Hinckley & Bosworth Borough Council
Interested Party Reference Number: 20039546

Deadline 3 Submission:
Response to Written Representation Comments

**Application by Tritax Symmetry (Hinckley) Limited for an
Order Granting Development Consent for the Hinckley
National Rail Freight Interchange**

(ref. TR050007)

Figure 2.2: Heavy Vehicles Trip Distribution to and from the Hinckley NRFI Development Site for 2026 and 2036 (in PCUs)

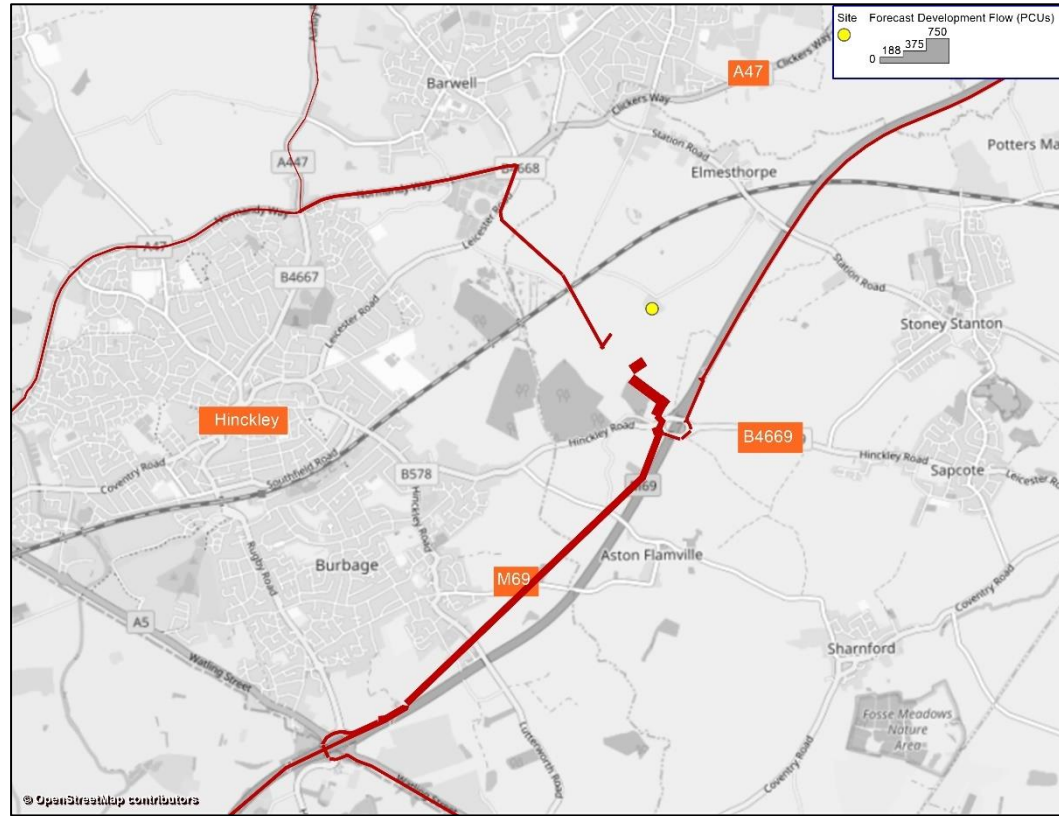
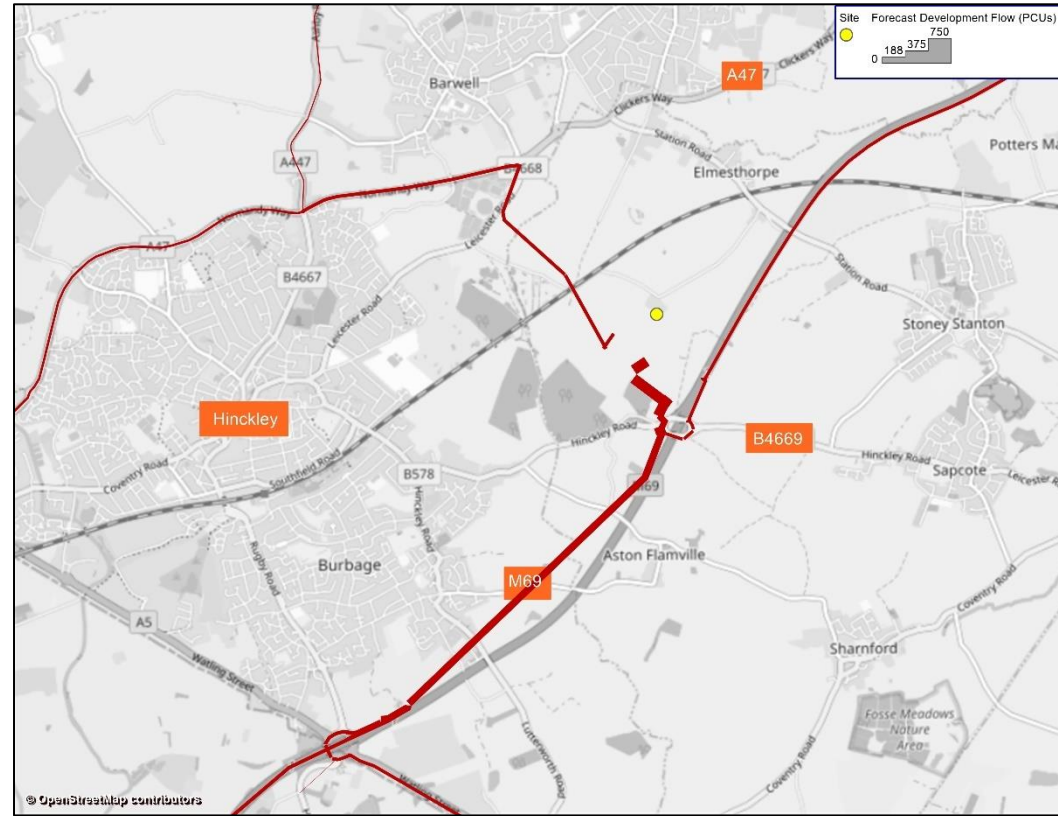
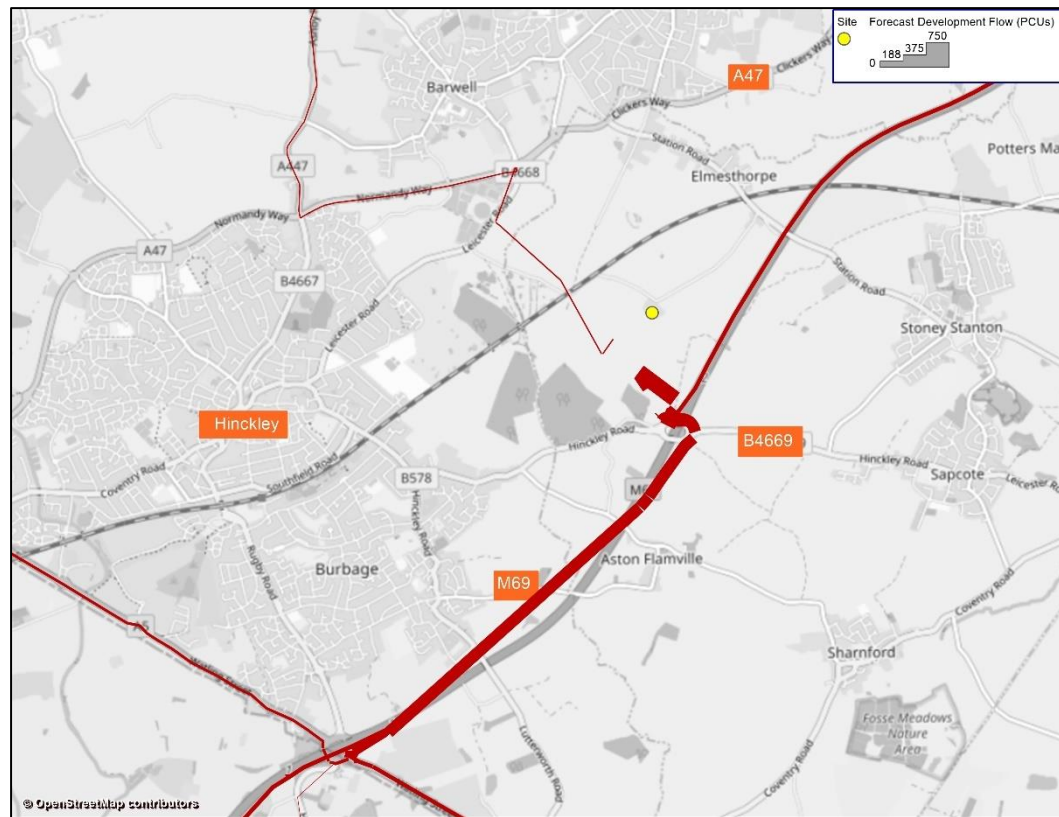
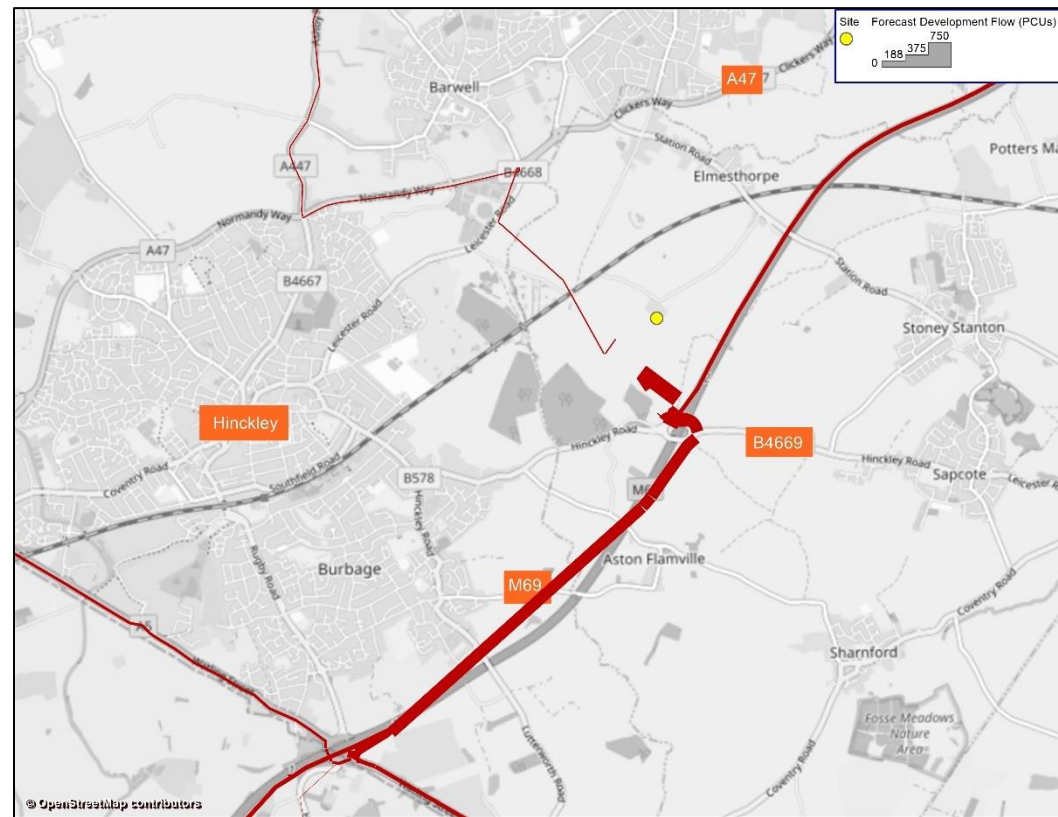
<p>congested J21 of the M1 and the statement that ‘the optimal maximum distance for the road leg is c 20 miles</p> <p>6.10 Its location within the Midlands region enables a network of rail terminals to work together allowing each to be used for the most efficient local distribution by electric HGV and increase the overall transfer of more freight to rail from long haul HGV.</p> <p>6.11 In terms of onward distribution, the rail element is one leg, with the next being either into an adjoining warehouse on the SRFI development, or into the surrounding region. For HNRFI, having worked with terminal operators with road haulage services⁴¹, the optimal maximum distance for the road leg is c20 miles / 45 minutes drive time.</p> <p>6.12 This means that the Midlands market will primarily operate such that:</p> <ul style="list-style-type: none">• West Midlands Interchange, will serve the Black County, Southern Staffordshire• Hams Hall will serve north Birmingham and along the M42, to Solihull.• Landor St will serve Central Birmingham,• BIFT will serve Tamworth and North,• HNRFI will serve Coventry through to Leicester South, including Magna Park for deep sea / east coast, west coast and domestic time sensitive flows. <p>However, in the applicant’s Traffic Distribution report (applicant document 6.2.8.1), Figure 18 indicates that only 20% of HGV trips from the HNRFI facility are in the 0-25 mile distance range from the facility . This implies that either the distribution is incorrect, or that this particular element of the needs case has not been included in the HGV trip distribution method used.</p>

Figure 3.3: Heavy Vehicles Trip Distribution to and from the Hinckley NRFI Development Site for 2026 and 2036 (in PCUs) (Longer Distance Trips to / from the North)

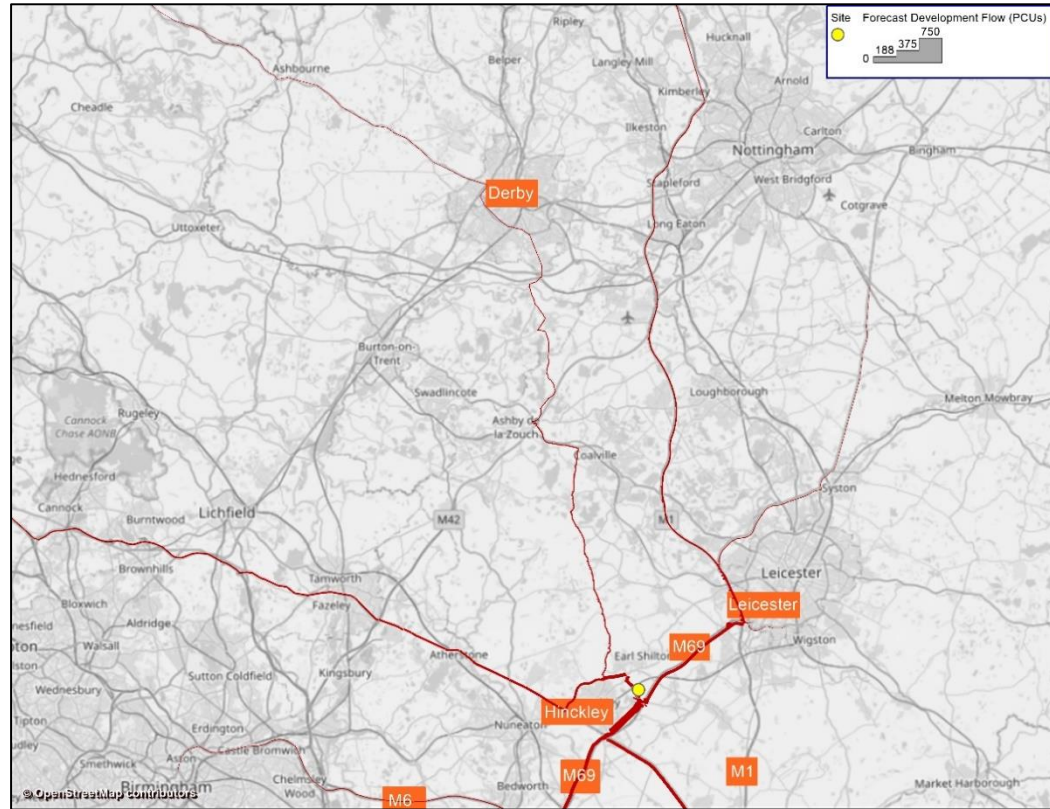
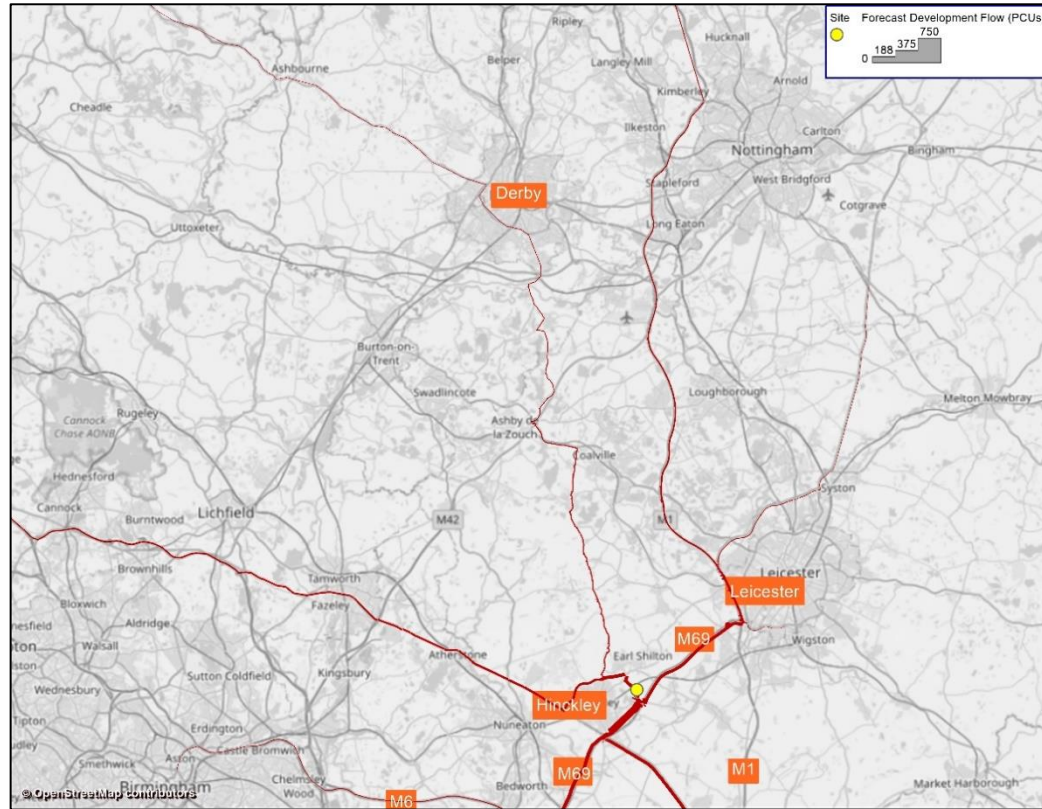
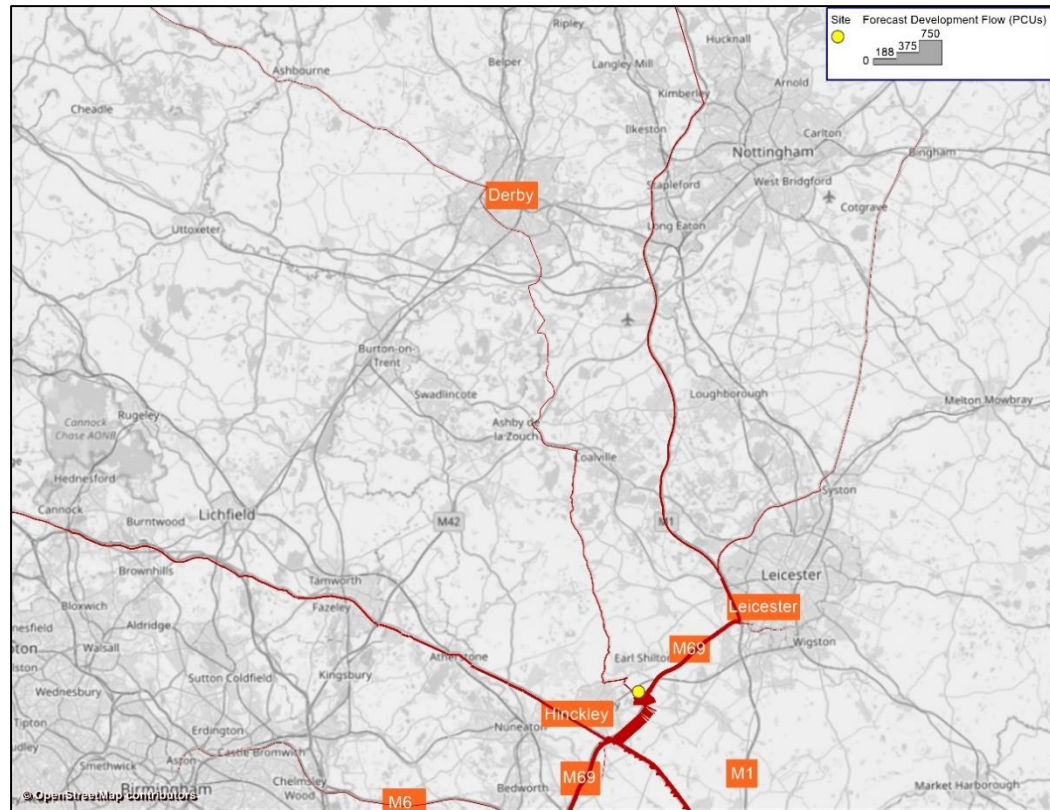
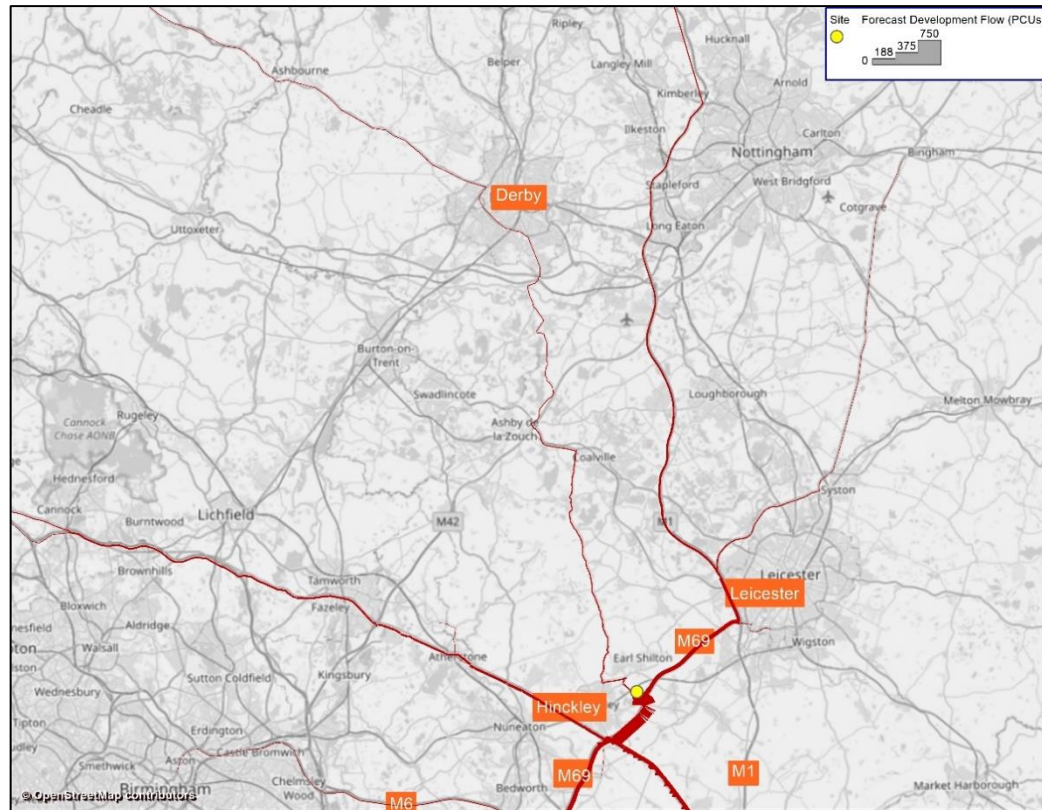
<p>these vehicles should use the A5 and M69 to and from the site. To do otherwise would mean that while the strategic case of the site depends on SRN access, this is severely compromised from two directions in the west and two North (J21 of the M1).</p> <p>The A47 is an A-road (and the B4468 is a B-road), but is 30mph (or 40mph) for much of its length; it has a shared use walk/cycle path along it and while it has little frontage development, it sits between the main parts Hinckley and new housing and employment areas to the west and the established centres of Barwell and Earl Shilton (as well as growing nearby villages such as Stoke Golding). In addition, the new SUEs (Barwell and Earl Shilton) are to the west of it. It is therefore a key severance element in the urban fabric of Hinckley, and the A47's original function may have been to 'bypass' Hinckley it has now been leapfrogged by development and its nature has changed. The route carries some HGV traffic, and this is expected, as it leads to some key employment areas. However the addition of all north/west bound traffic from the HRNFI will mean a very significant increase in HGVs on the route, to the detriment of the environment of the surrounding communities and the people needing to cross the road, particularly by walking and cycling.</p> <p>The Council notes that in the Traffic forecasting report (applicant document 6.8.1' it states:</p> <p><i>'3.2.3 For heavy vehicles, a greater proportion of the trips from the west is forecast to route via the A5, turning left at the A5 / A47 Dodwells roundabout to continue on the A47 then joining the proposed link road as shown in Figure 3.2. This route is considerably shorter than the M6 and M69 route, and given the higher operating costs for heavy vehicles, this is the more attractive route. In addition, heavy vehicle speeds are lower than those of light vehicles on the M42, M6 and M69 (limited to 60mph), as such heavy vehicles are forecast to route via the A5 rather than the M69.</i></p> <p><i>3.2.4 As shown in Figure 3.3, a small proportion of heavy vehicles is also forecast to route via the A447 Ashby Road to / from the north</i></p>

<p><i>(approximately 25 vehicle trips on Ashby Road, immediately north of the A47 in the 2036 AM Peak hour). These trips have an origin and destination in locations including Coalville, Ashby-de-la-Zouch and beyond (including Derby). Routeing via the M1 and M69 is approximately 8km longer from Coalville than routeing via Ashby Road. Journey times between the two routes are comparable for light vehicles, however routeing via Ashby Road is faster than routeing via the M1 and M69 for heavy vehicles given the lower motorway speeds. In addition, vehicle operating costs for heavy vehicles are higher per kilometre than light vehicles, making Ashby Road more attractive’.</i></p> <p>It is clear that without effective HGV management, HNRFI HGVs will avoid the SRN and have a greater impact on local roads. The impact on Ashby Road by HGVs is also of concern to the Council.</p> <p>The HNRFI traffic should be required to use the A5 and M69, with local access HGV traffic only being permitted to use the link road to the west.</p> <p>The Council notes that the strategy also indicates (para3.12) that ‘In case of an accident on the Strategic Road Network, there will be an emergency plan in place which will include alternative routes to/from the Main HNRFI site. This is likely to make use of the A47 connecting the A5 with the site and the SRN to the north but will be confirmed with the relevant authorities.’ This will have a very significant impact on the A47 and the local communities close by it. We note that the development proposals reduce all residence on the M69 to the north and will impact resilience on the south.</p> <p>The Council awaits with interest the outcome of the ExA request made at ISH2 for the modelling of the impact on the local highway network of a scenario where access to or from the M69 is unavailable.</p>
